**RESPONSE TO REQUEST FOR ADDITIONAL INFORMATION
SSD 7388 MOD 14 – 31 WHEAT ROAD, SYDNEY (THE RIBBON)**

This letter has been prepared by Ethos Urban on behalf of Tianlong Ribbon Pty Ltd (Greateon), in response to the Requests for Additional Information (RFIs) for SSD 7388 MOD 14 issued by the Department of Planning, Industry and Environment (DPIE) dated 5 November 2021. It also responds to additional items raised in email correspondence by Jennie Yuan (Planning Officer, Key Sites Assessments) dated 22 November 2021.

BUILDING 2
GA PLANS

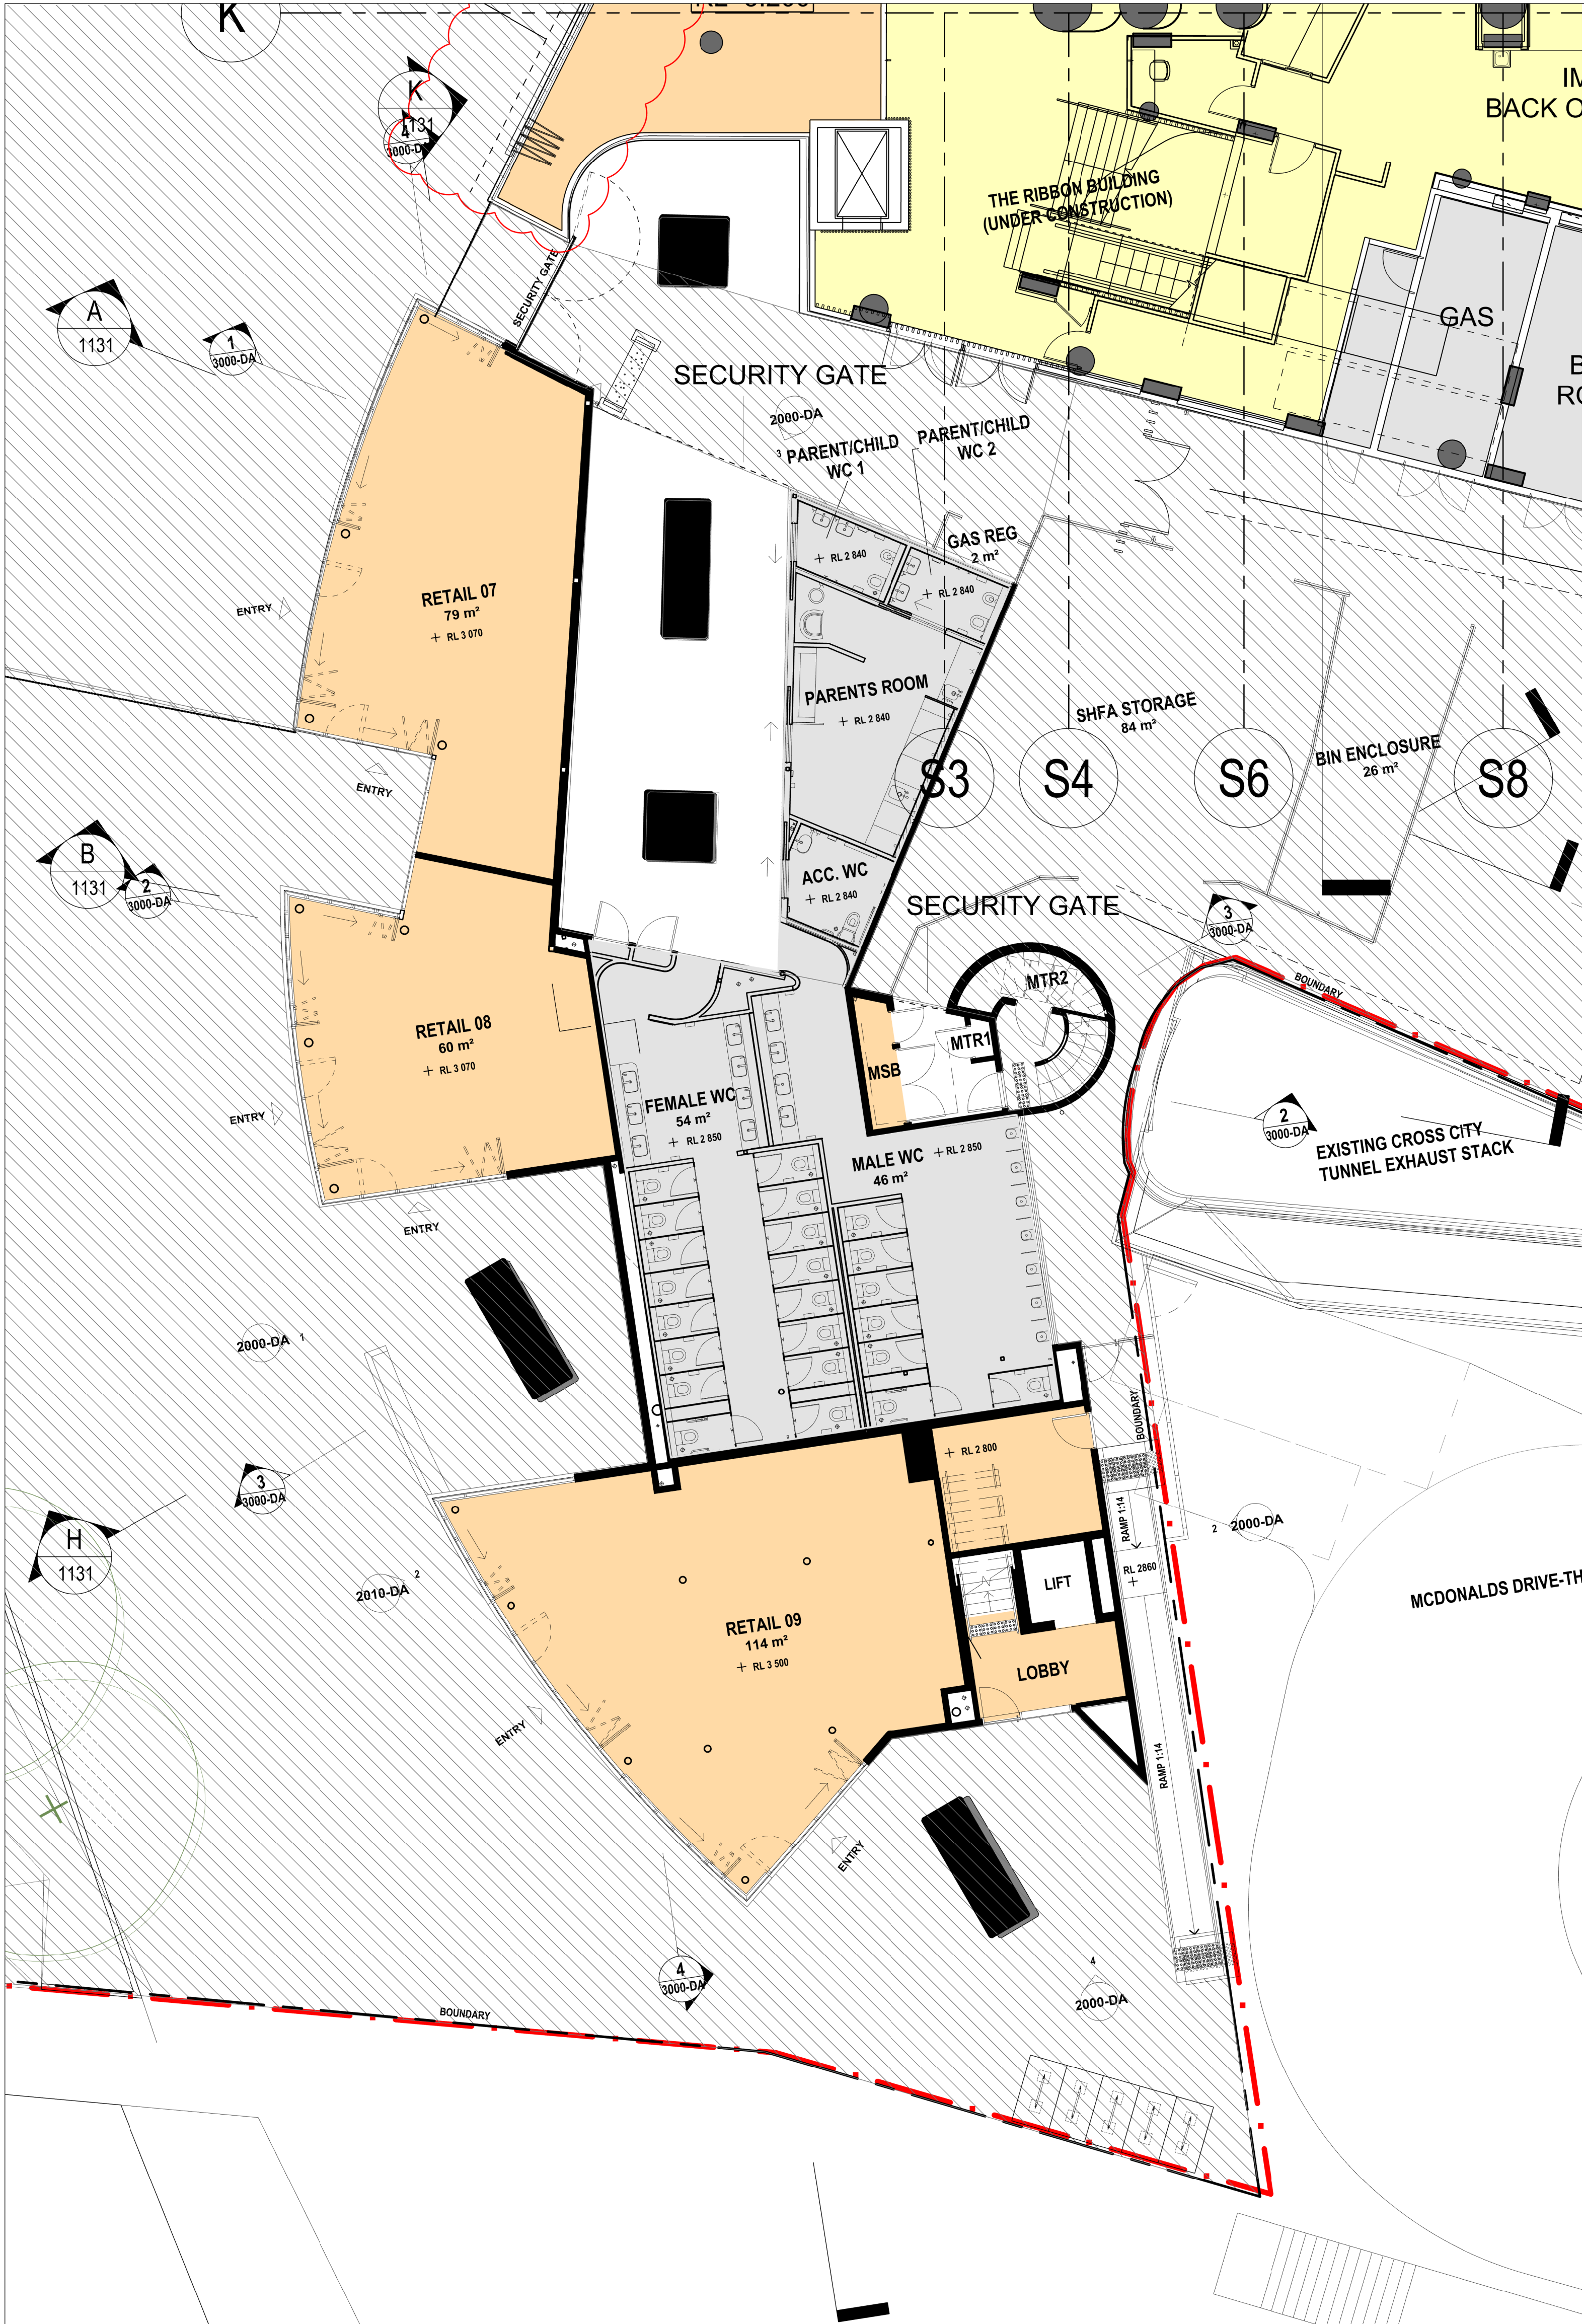
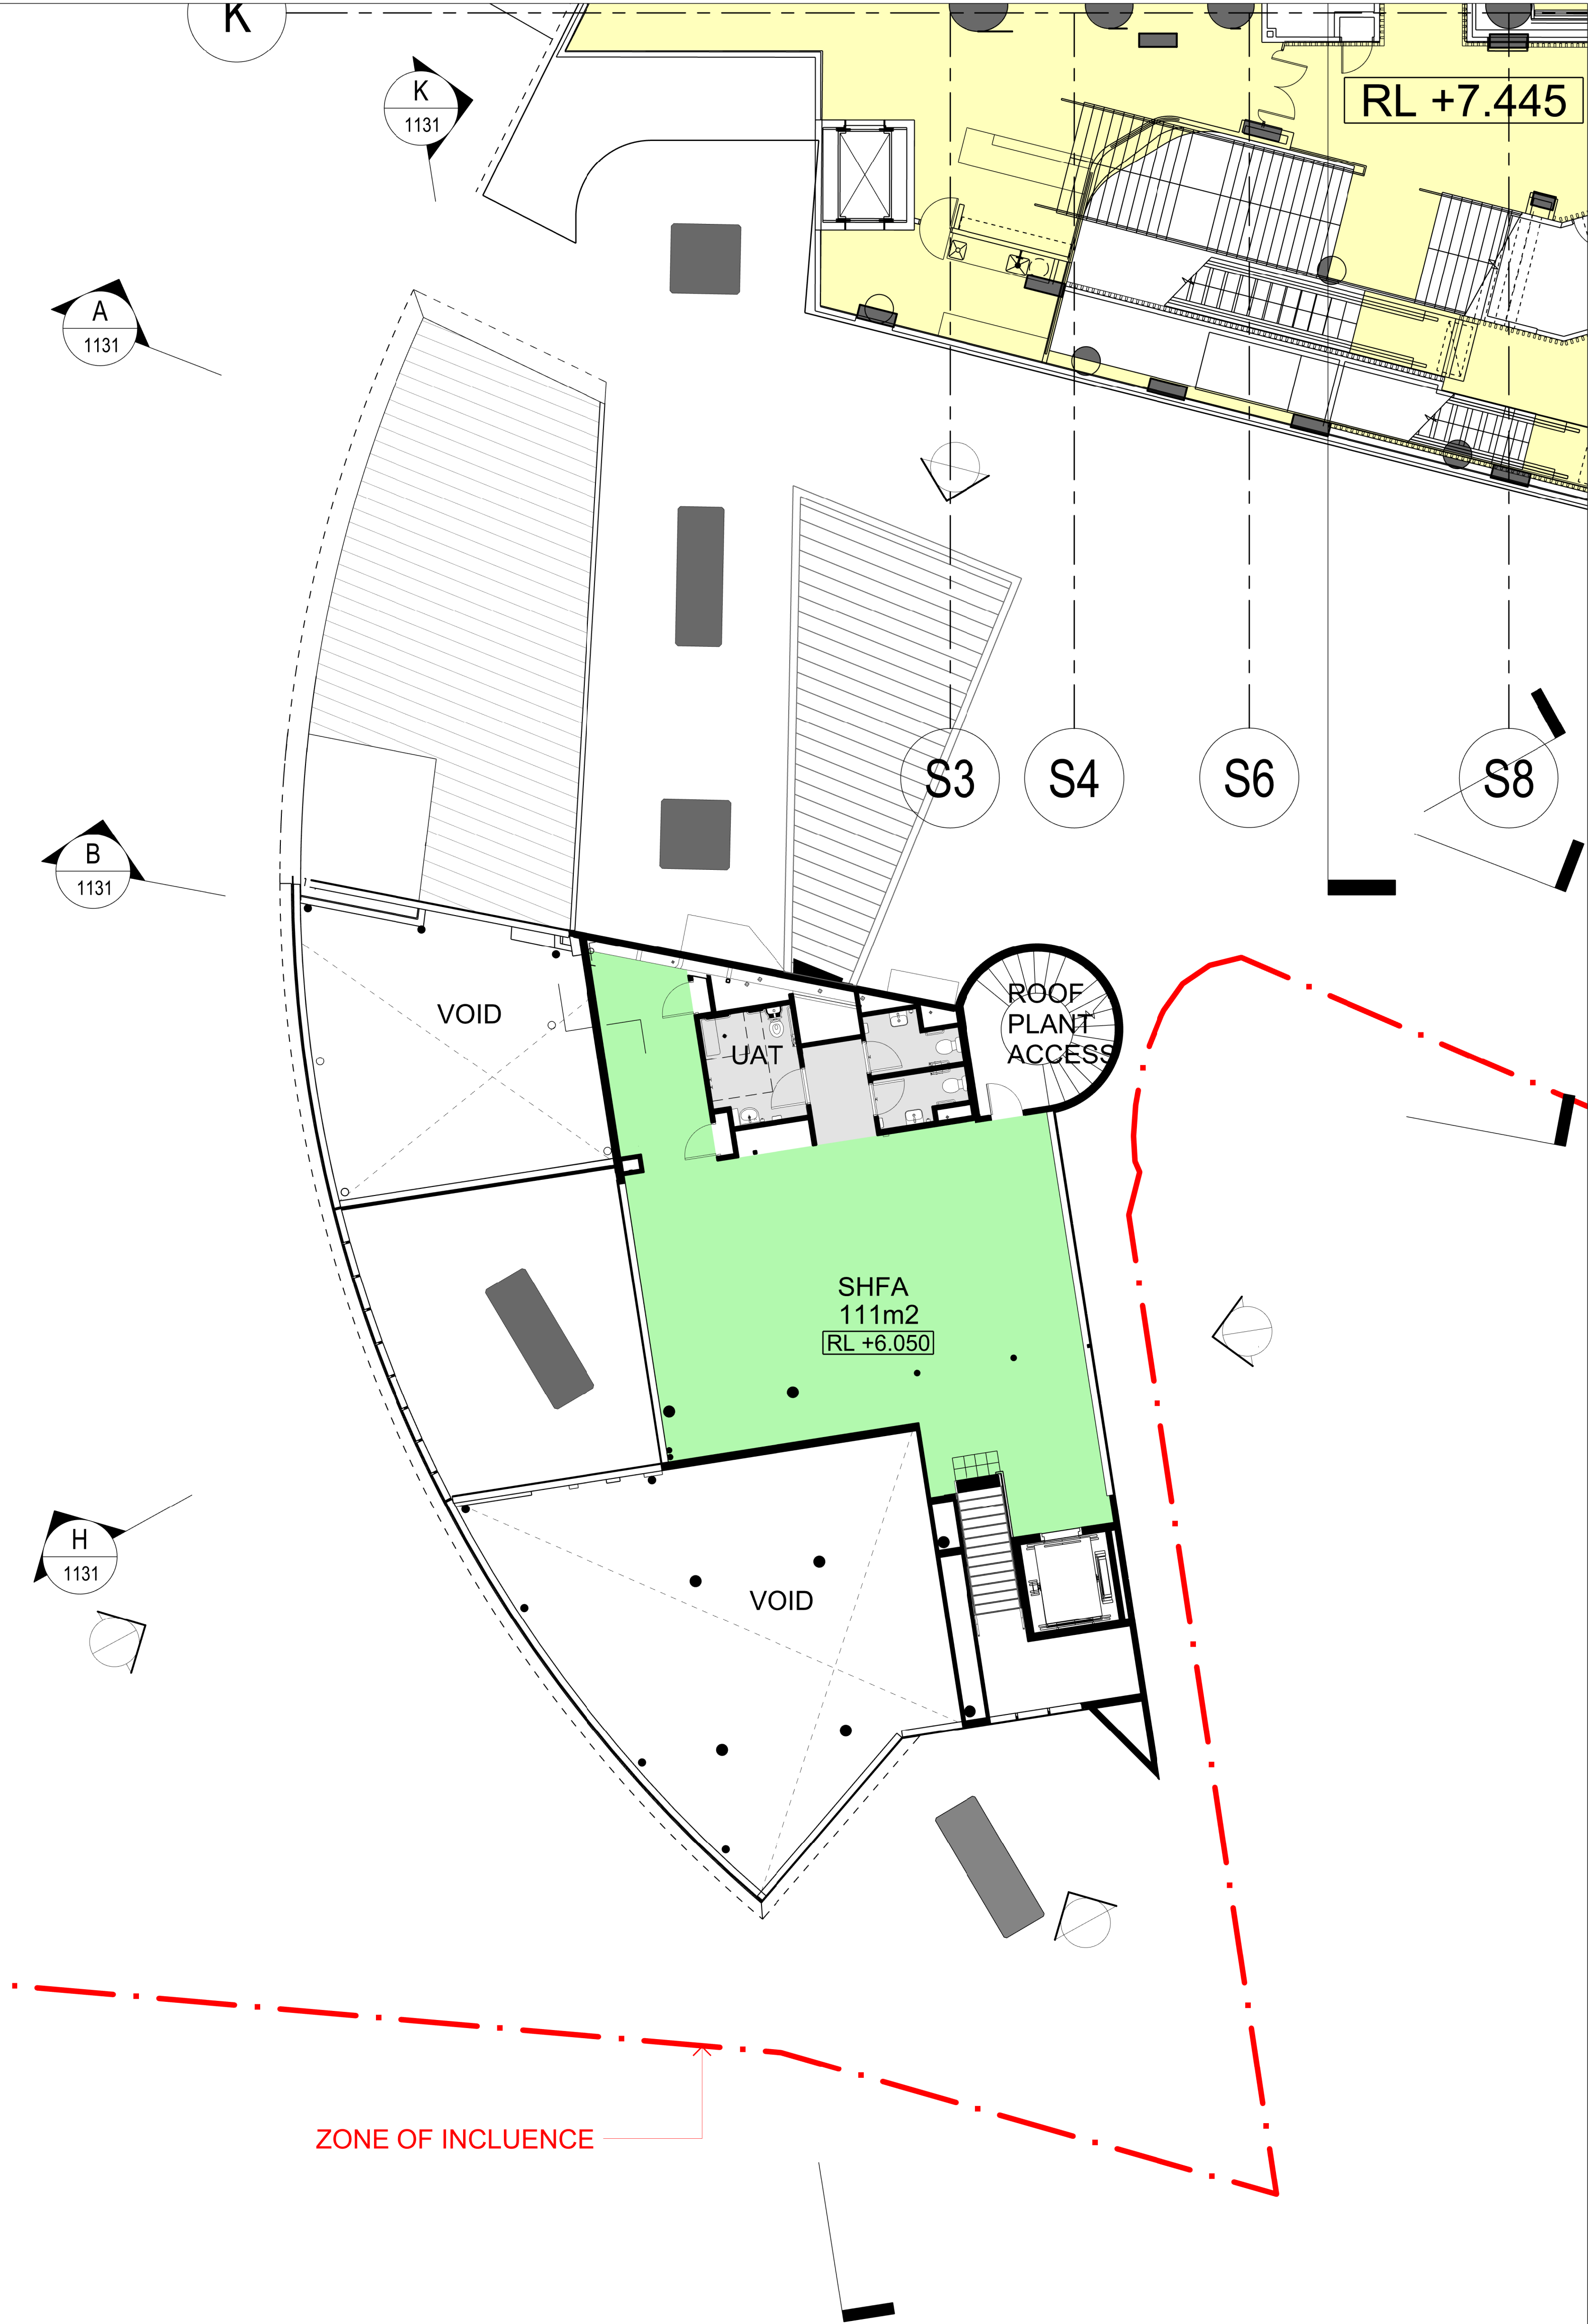
Response to email correspondence – 22.11.2021	
<p><i>Please check and confirm the proposed total GFA and the GFA of each level (the numbers/levels between Attachment A Page 1 and Attachment B Page 5 seem not matching)</i></p>	<p>The GFA Plans submitted at Appendix B of the MOD 14 package were only for information purposes. The Updated Architectural Plans at Attachment A provide the final confirmed GFA figures for the building.</p>
<p><i>Please confirm the proposed increase of GFA (my calculation is 968 m2 if we use the total GFA numbers in MOD 10 and Attachment A Page 1 while the report states 986 m2)</i></p>	<p>968m² is the correct figure. There was a drafting error in the originally submitted report.</p>
<p><i>Please confirm the design of the space in the south of the lift lobby (the layouts look different between Attachment A Page 6 and Attachment B Page 7 & 9) and whether it is going to be used for serviced apartments.</i></p>	<p>The confirmed layout of the space is shown in the Updated Architectural Plans at Attachment A. The layout is approved and does not form part of the MOD 14 scope.</p>
